CITY OF ALBUQUERQUE

March 3, 2017

RE: **Galles Chevrolet Grading Plan- For Foundation Permit Only**
University and Candelaria
Engineer's Stamp Date 1/27/2017
Hydrology File: H15D065

GRADING &
DRAINAGE PLAN
(2 OF 3)
CG-102

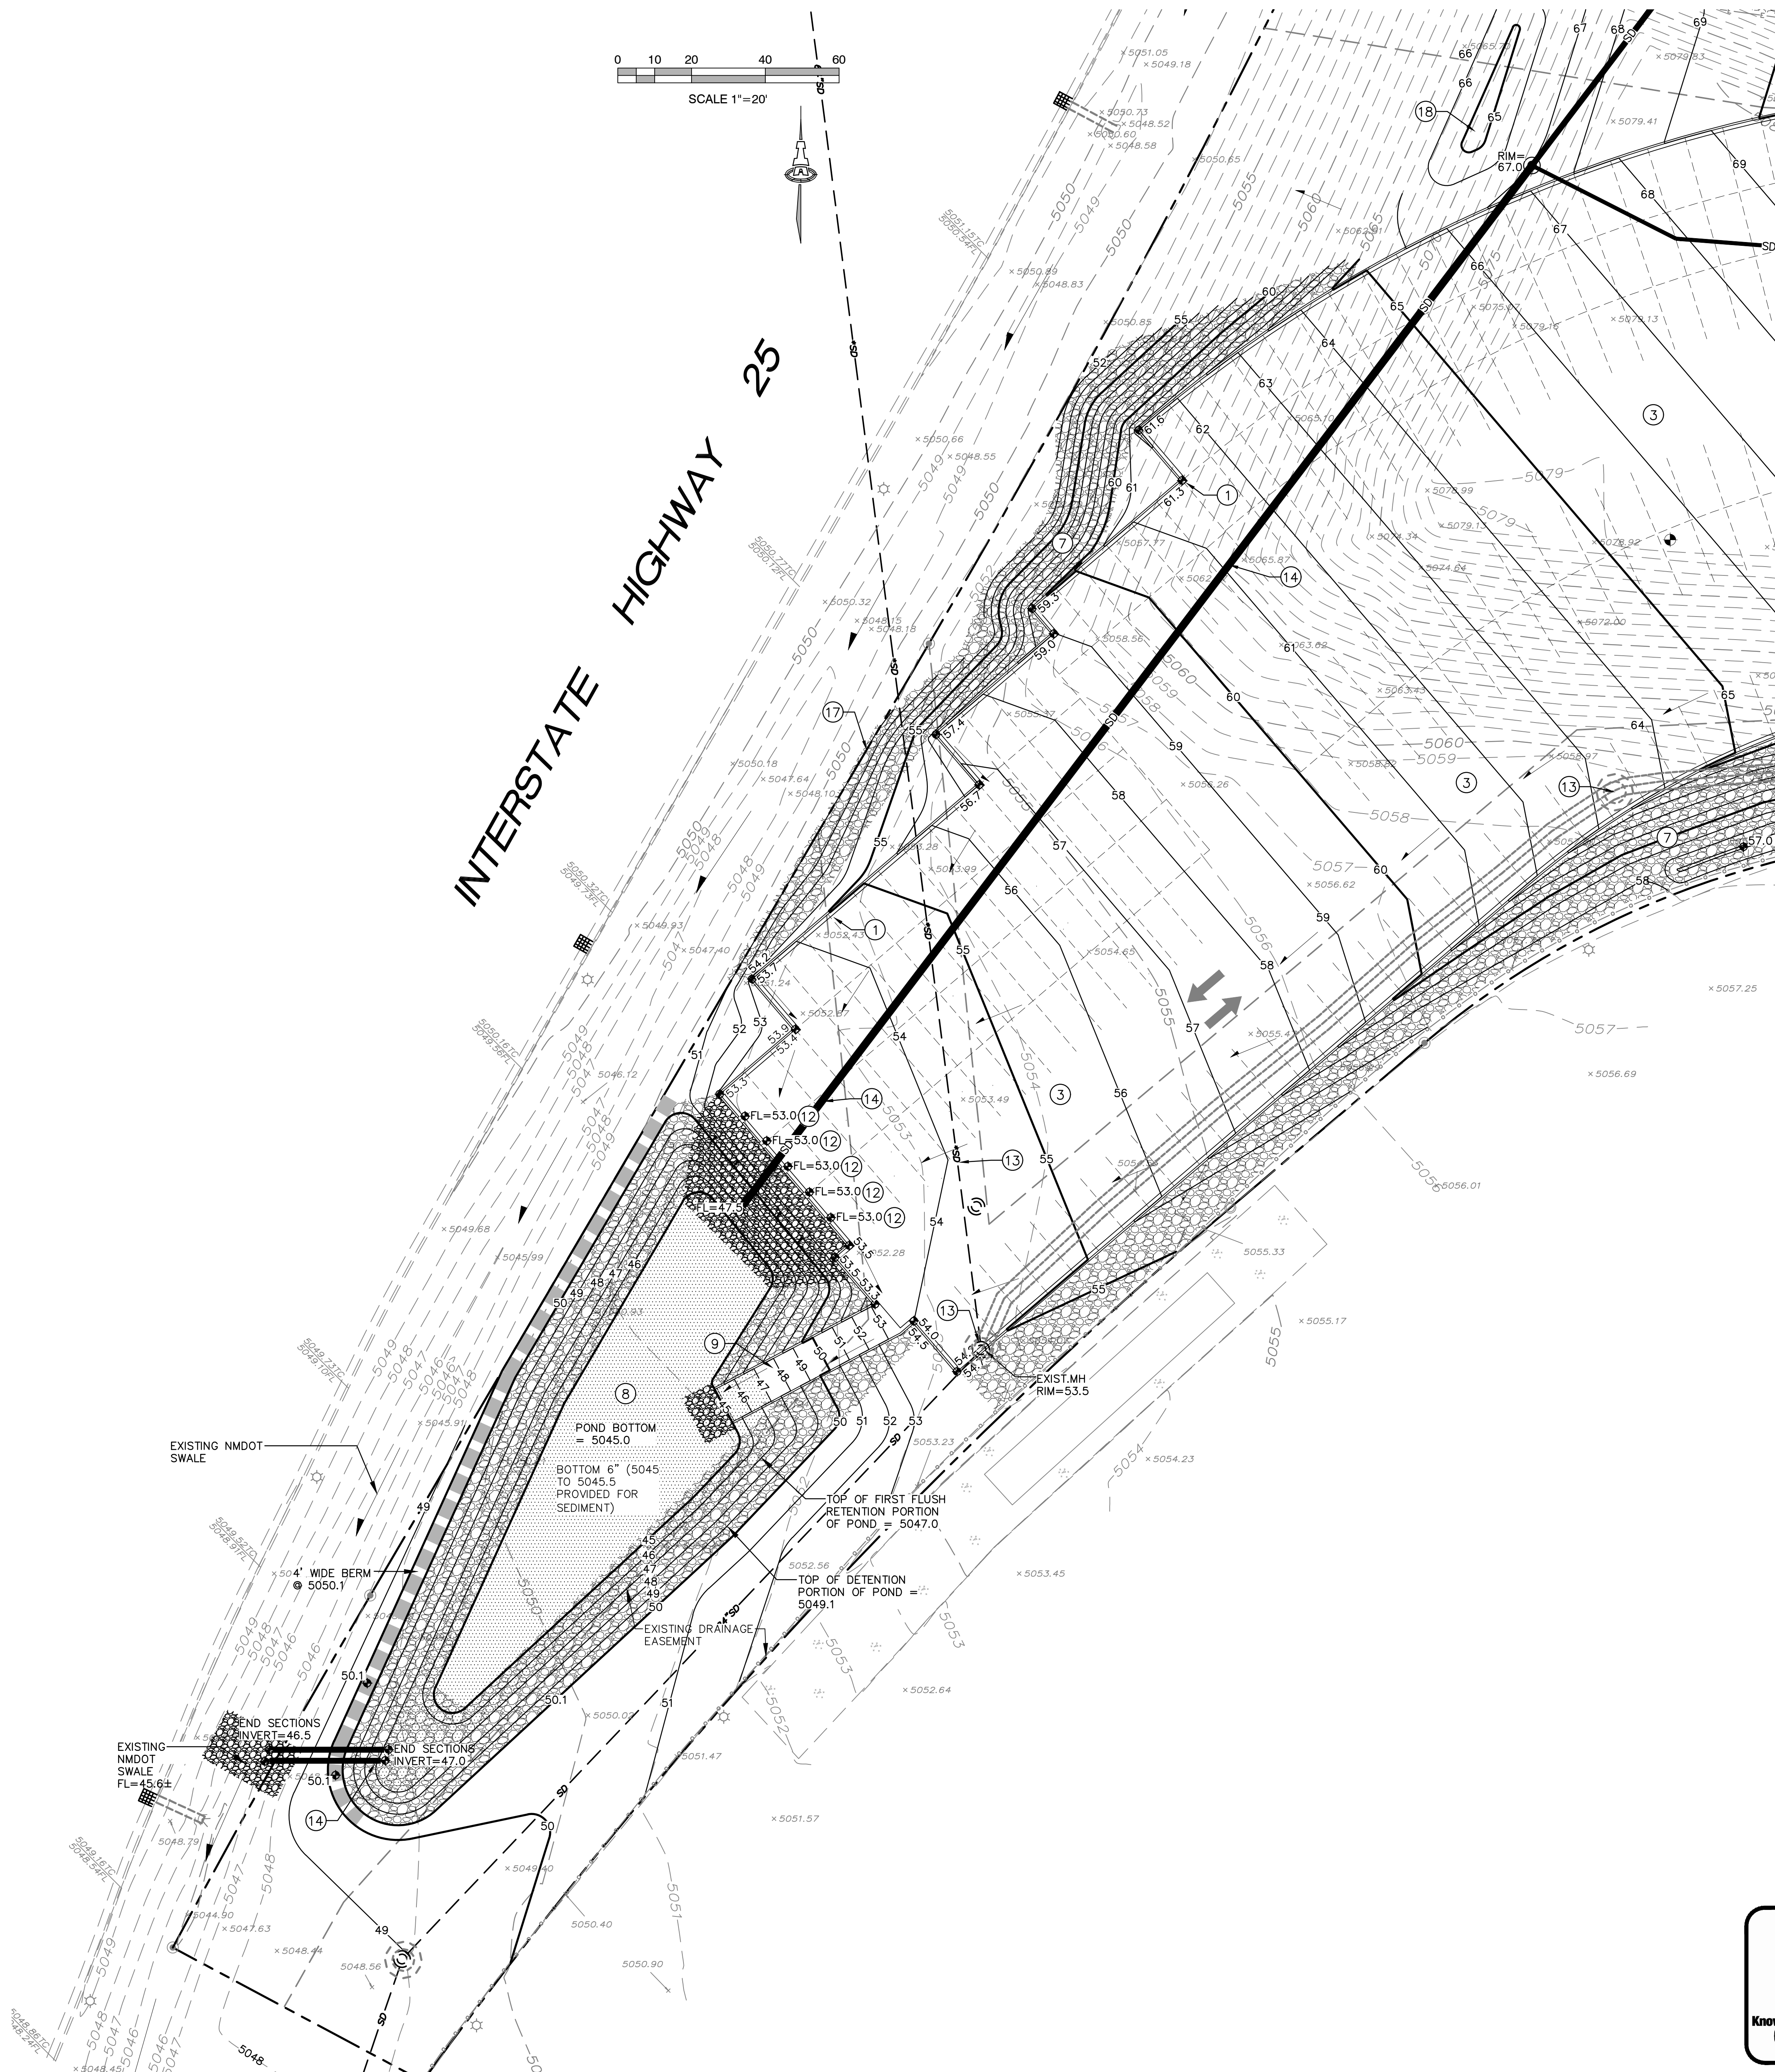
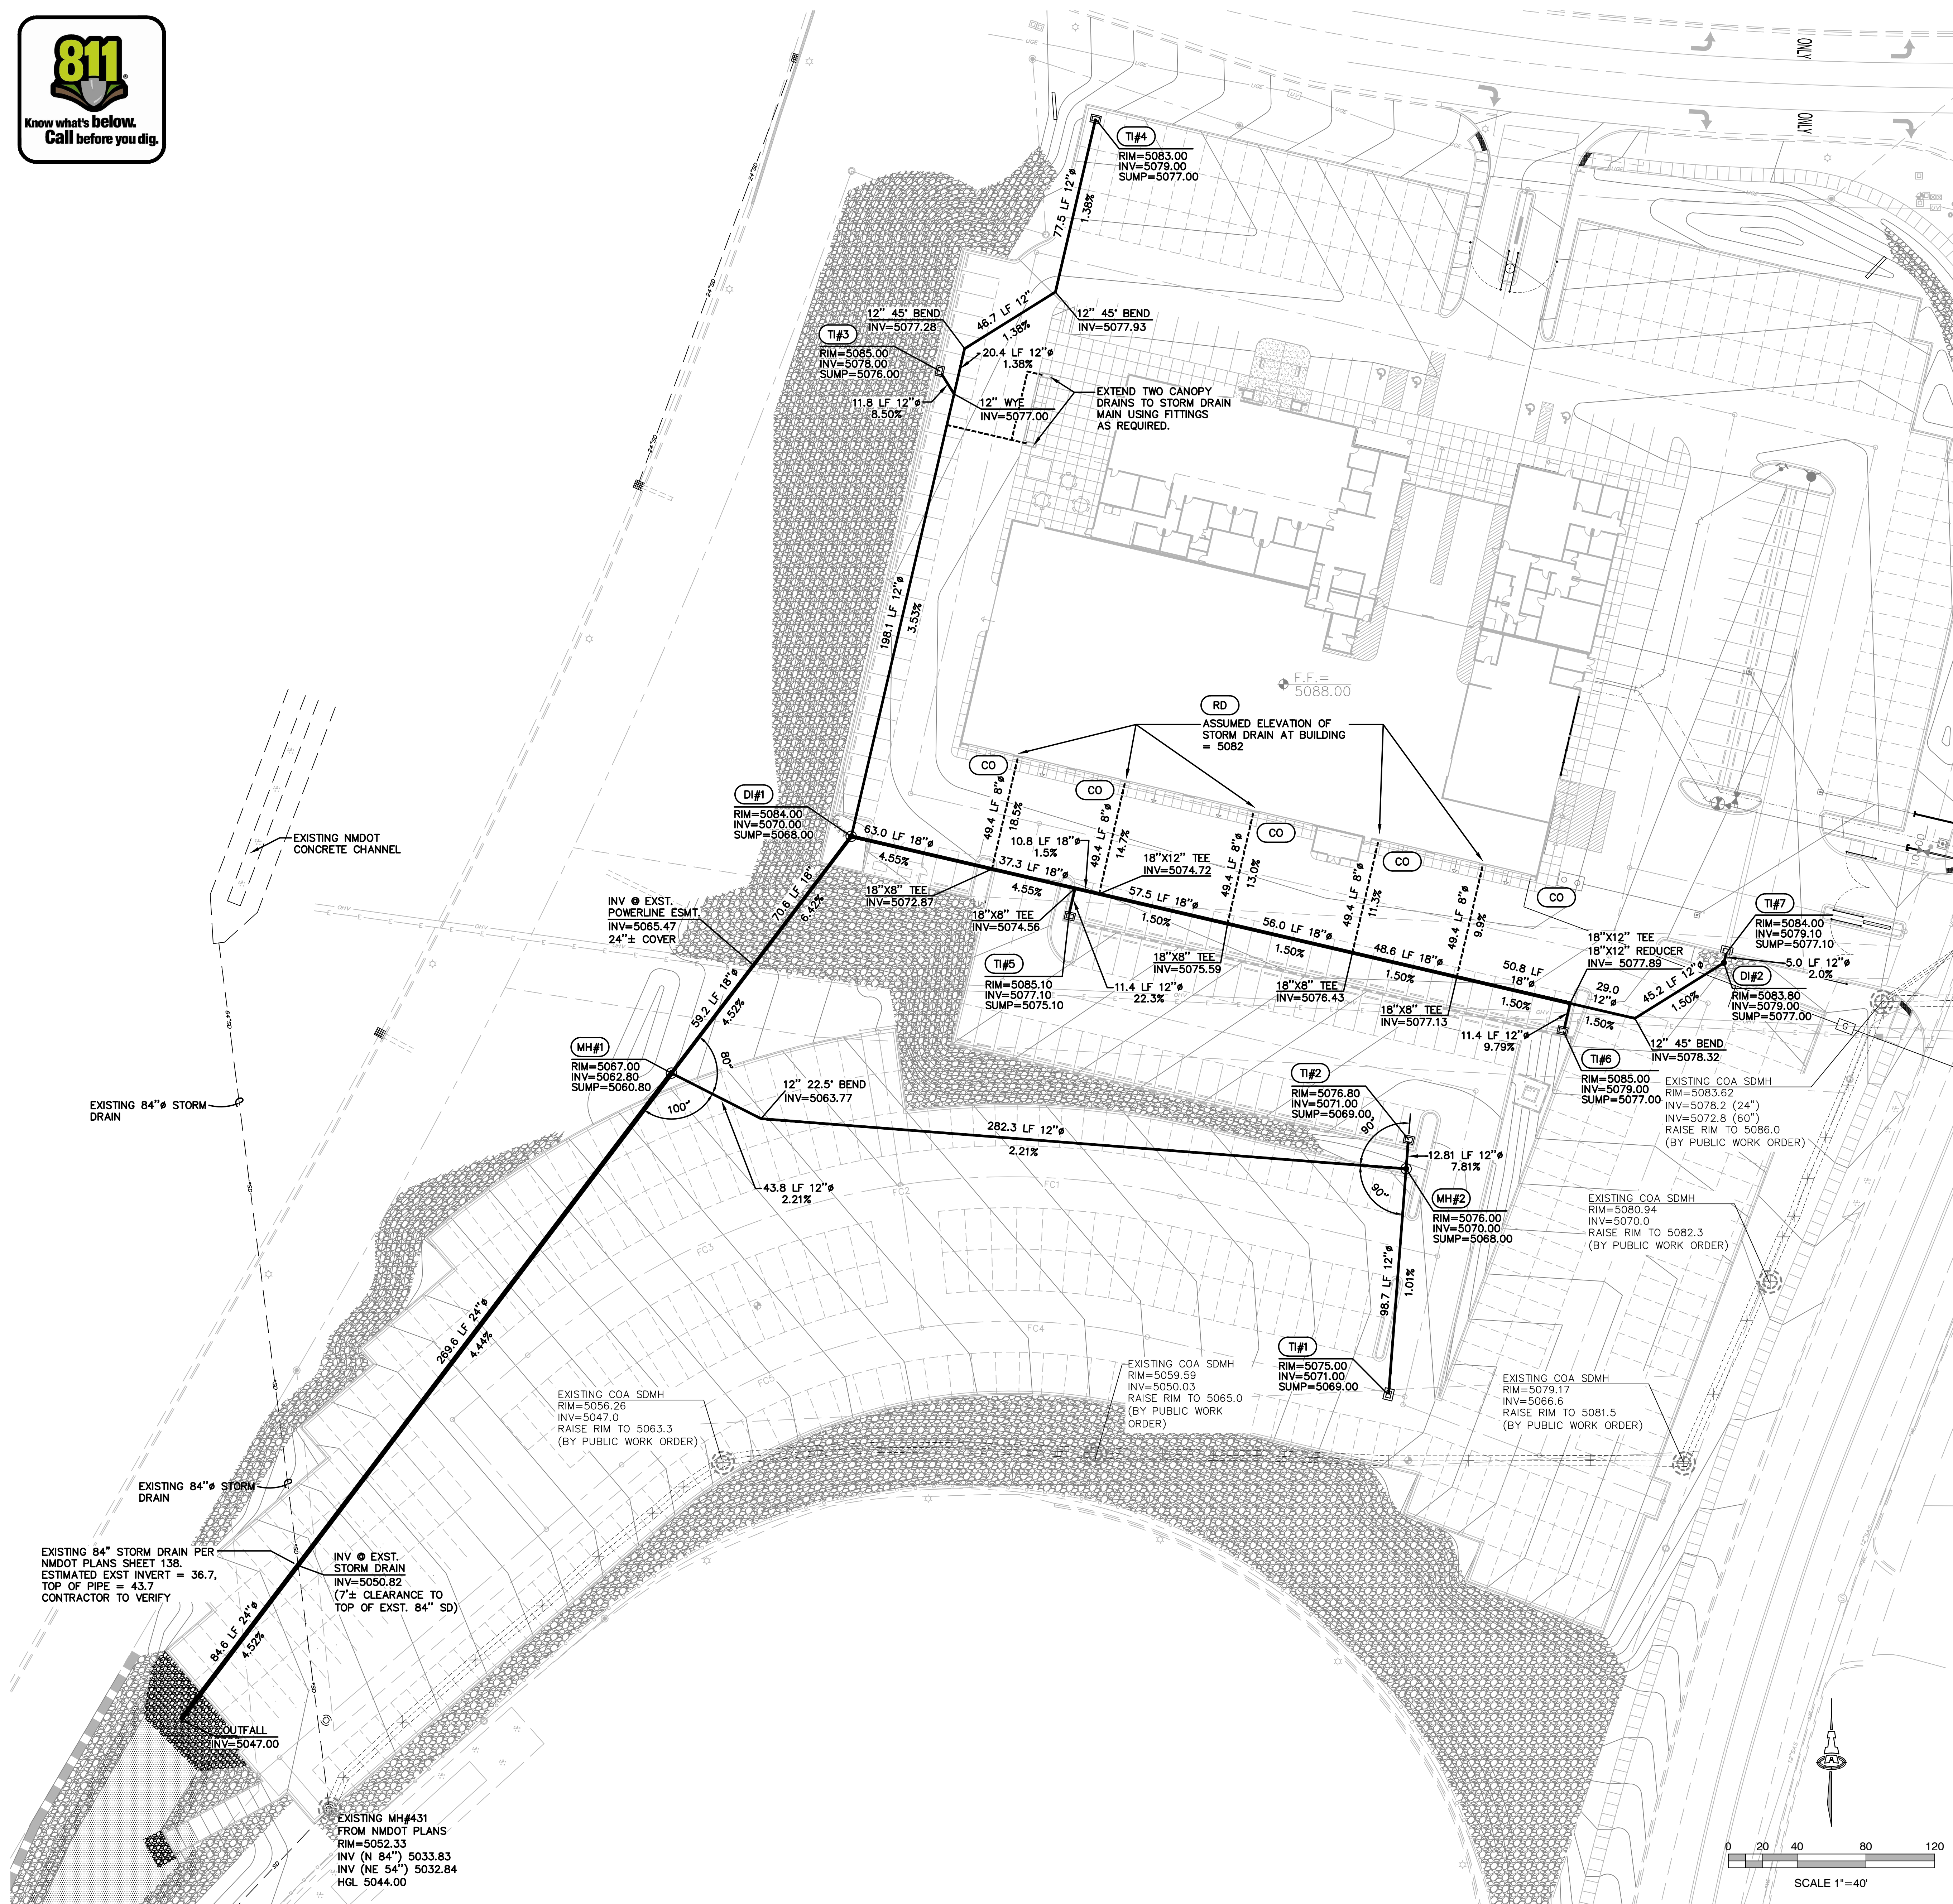
- a. Provide a detail of the proposed wall over the public storm drain easement at the south end of the lot. An encroachment agreement may be required by NMDOT for this work, as they are the owning agency for that storm drain section.
- b. Provide details to show the existing storm drain manholes will be protected including rim and surrounding spot elevations. Add note to protect in place and warp sloping if necessary to prevent them from being buried. Modifications to raise/lower rims may be made through SO-19 permit or mini-work order if this is necessary. Future access to Manholes must be provided and coordinated through Storm Drain Maintenance.

- a. Add dimensions to include pond volume, bottom of pond, maximum water surface elevation, and side slopes.

- b. Side slopes greater than 3:1 will require a fence or barricade. This appears to be an issue along the west side of the pond adjacent to the frontage road.
- c. Provide an outfall for the pond. It is Hydrology's understanding the pond will outfall to the NMDOT swale along the frontage road. Permission to discharge to this location must be obtained from NMDOT and may require discharge to be restricted to the pre-development condition.

- a. Provide proof of coordination with NMDOT-District 3 Drainage Engineer for work in their ROW and easement. It appears that there is grading and a retaining wall in their ROW at the northwest corner of the site. Also they will need to approve any pond outfalls to their roadside swale.
- b. Provide proof of correspondence with PNM for grading around the utility pole. PNM may want a buffer left around the base of the pole.
